Planning Application Ref: A/122/19/OUT

Location: Land off Arundel Road Angmering BN16 4ET

Description of works: Outline application with some matters reserved for the erection of up to 160 dwellings with public open space, landscaping and sustainable drainage systems (SuDs), vehicular access point from Arundel Road together with up to 557 square metres of B1/B2 units with associated parking provision & vehicular access point from Arundel Road & land made available for expansion of current sports pitch provision to form a sports-hub (following the demolition of existing commercial units and one bungalow) (resubmission following A/36/18/OUT). This application is a Departure from the Development Plan

Tree Officer / Parks and Greenspace Team

Figure 3.8: Tree Survey.

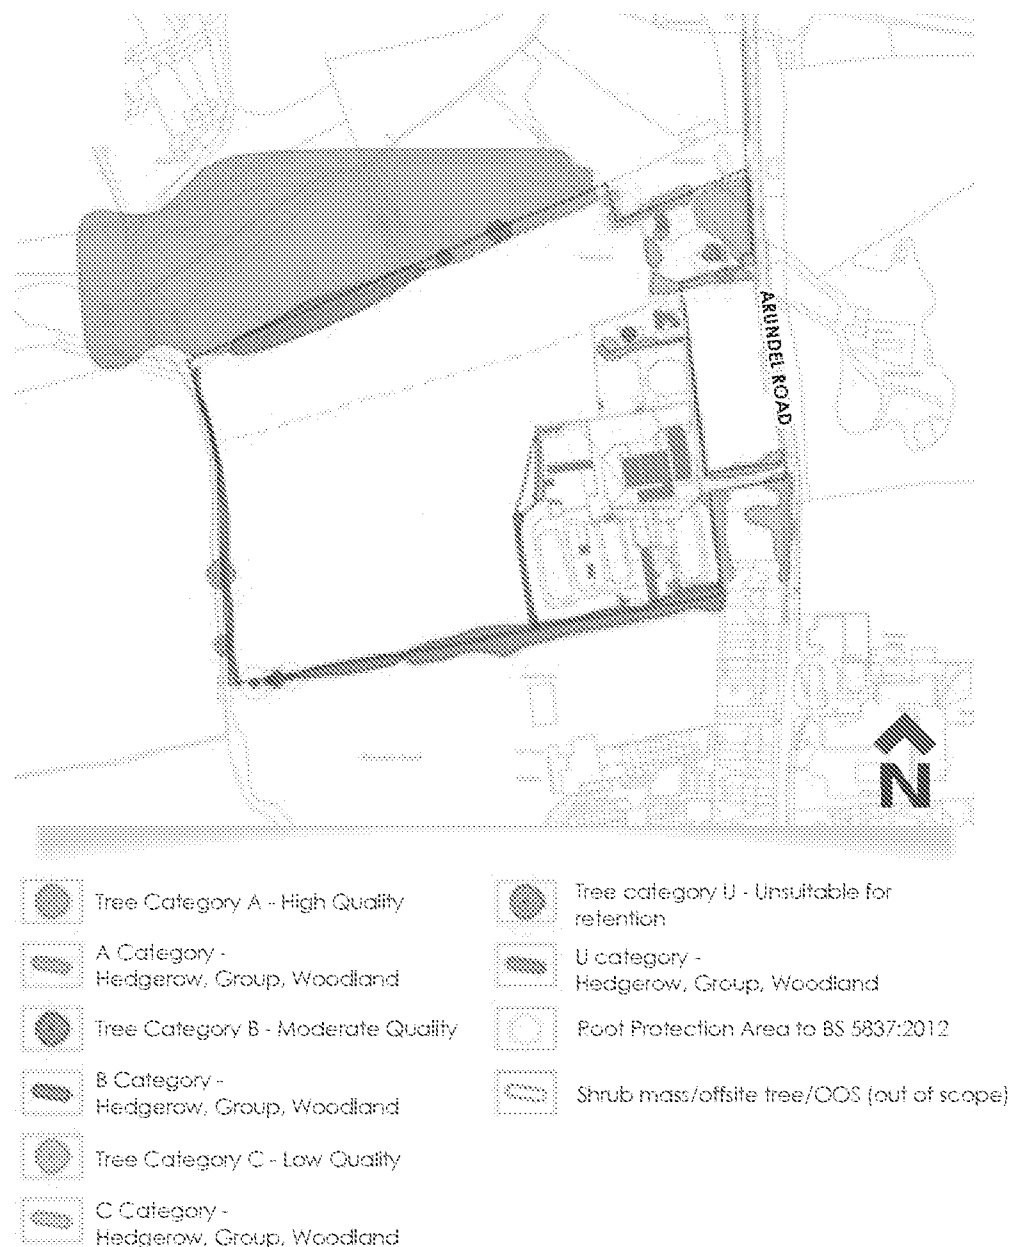
- The Tree Survey data is comprehensive and accords with the requirements of BS5837:2012. I agree with the retention category ratings for on and off-site trees. Some of these trees possess considerable landscape value, most of which are Category A and B specimens and so should have considerable influence over any development proposal.

Figure 5.1: Development Framework Plan.

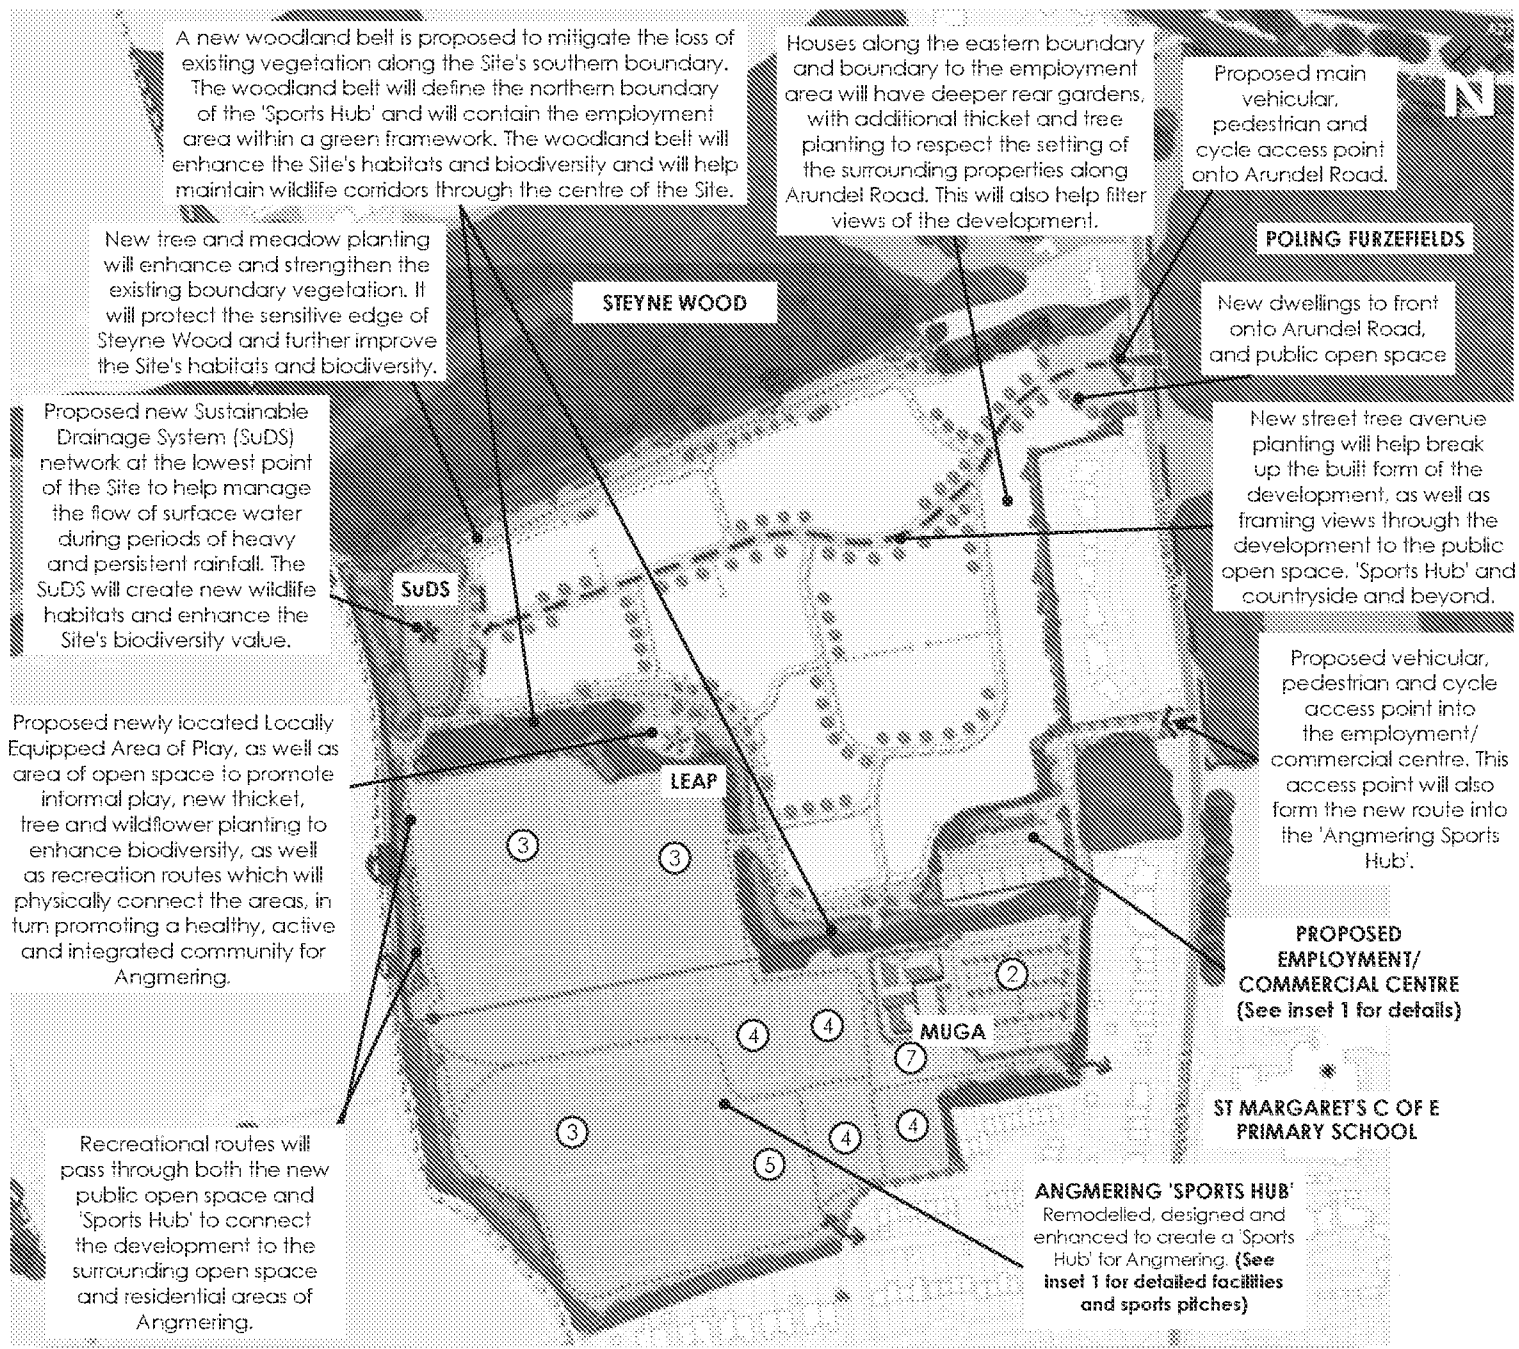
- **Development Framework Plan, dwg. no. CSA/3467/136, Rev A** - The current proposal shows the majority of Category B trees would be removed to accommodate the layout of sports pitches (3. senior football). It seems unlikely that those trees within G14 and individuals to the west can be successfully retained for the long-term and in harmony with the location of those pitches. As stated in the AIA report, the loss of those trees can (and I would add 'should') be mitigated through the provision of significant tree planting as indicated on the above plan. 'Significant' in this instance should be interpreted as being of sufficient density, quantity and species type to ensure the linking together of current and proposed green infrastructure both within and adjacent the site perimeter. Those objectives should be met within a detailed landscape plan, yet to be submitted.

- The Category A and B trees growing to the north and west along with their associated groups and hedgerows – have significant landscape value and are strategically important for the accrual of ecological and environmental benefits for this site and its environs.

- The two Category A oak trees (T8 and T9) should be given adequate room both above and below ground, to both fully respect their nominal root protection area and allow for uninhibited future growth. This consideration should include their potential to attain veteran status and be accommodated without being subject to any risk mitigation pruning works in the future.
